Comments on any further information and submissions received at Deadline 3

by Anne Heard Interested Party reference 20054475

Comments on Springwell's response to Deadline 2 submissions REP3-074

Section 3.2 Response to Anne Heard's Deadline 2 Submissions Table 3-2 Use of large scale solar farms by bats

TITLE: FIGURE 12.3: DAYTIME  
OPERATIONAL NOISE  
CONTOURS

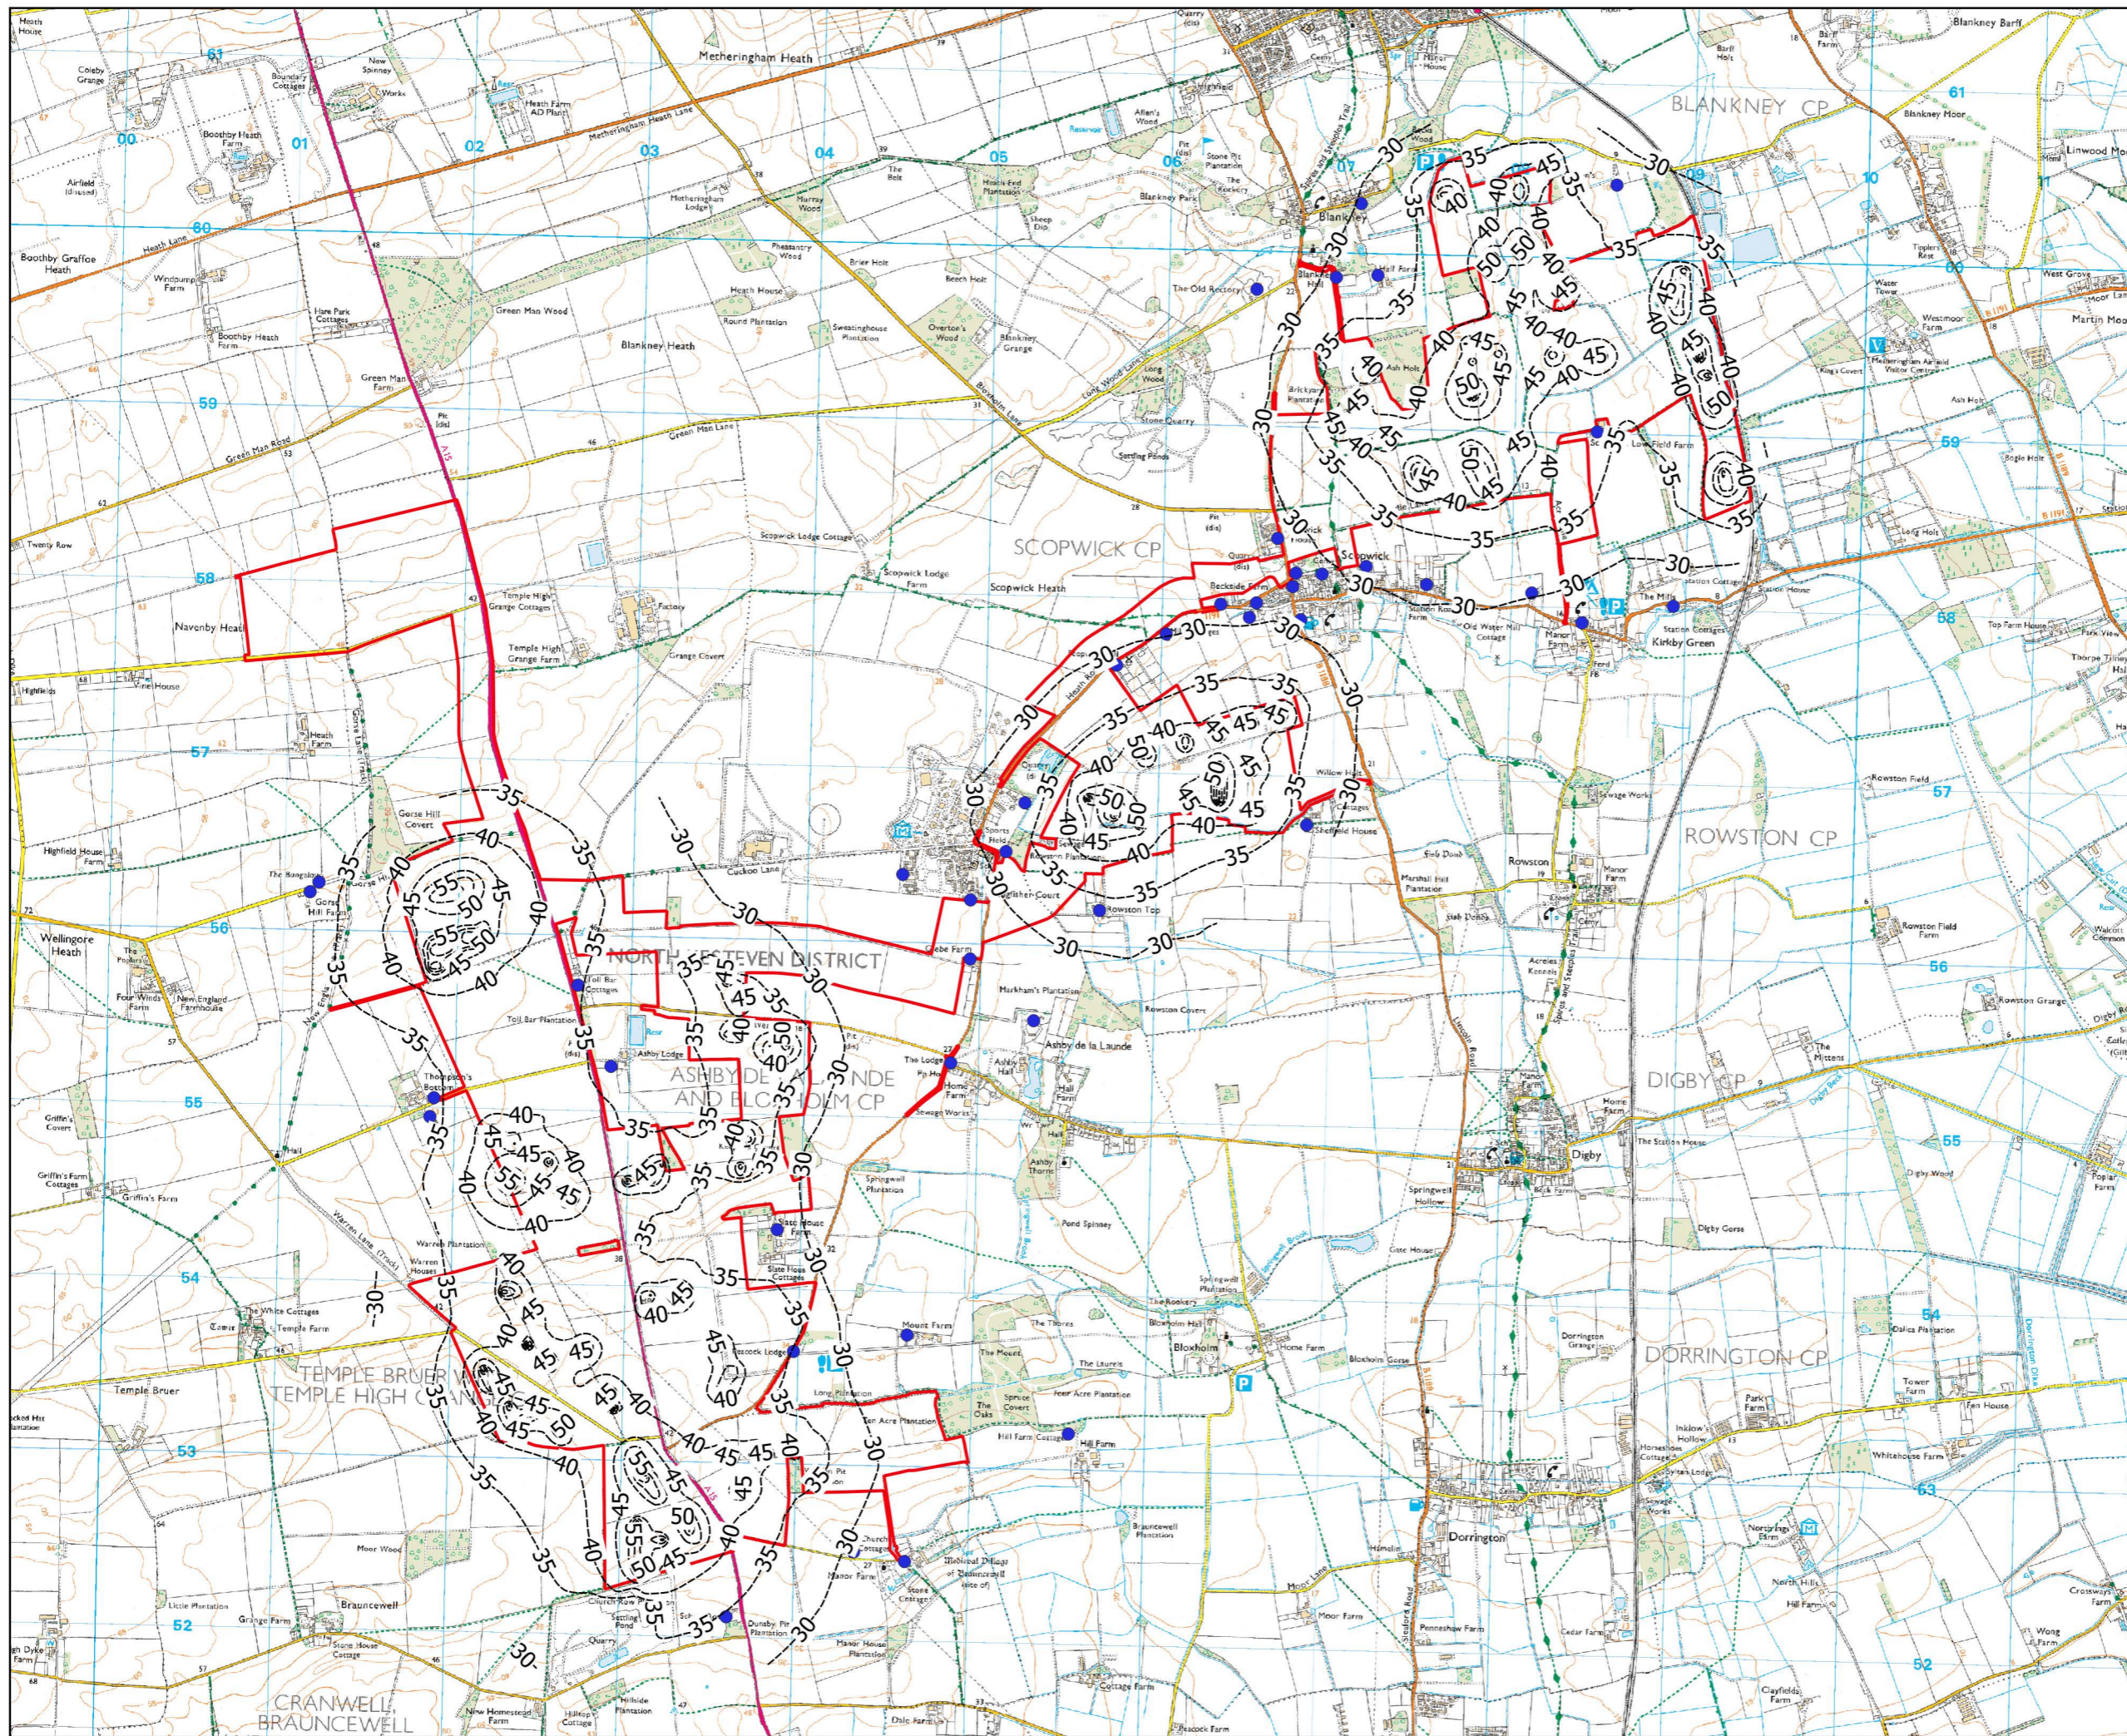
Chapter 12 Biodiversity (APP-047) Figures 12.3 (Daytime operational Noise contours) and Fig 12.4 (Night-time operational noise contours) shows large areas of land where the noise levels will exceed 50bBA (see Reason and Bentley above) and tracts of land where the noise levels will exceed baseline levels, particularly within Gorse Hill woodland and the western boundary of the proposed BESS, areas which the Applicant has identified are likely to be used by foraging and commuting bats and

elsewhere within the order limits where “several hedgerow trees support potential roost features”. As advocated by West (see above) these areas which will be subject to noise above baseline levels should be assessed for impact on roosting and foraging/commuting bats.

The suggestion by the Applicant that the bats will simply move to alternative commuting routes if they are affected by noise from the proposed development (paragraph 7.7.26 of APP-047 refers) begs the question of where they would go, given that anthropogenic noise will be audible throughout most of the 1280 ha of the Proposed Development.
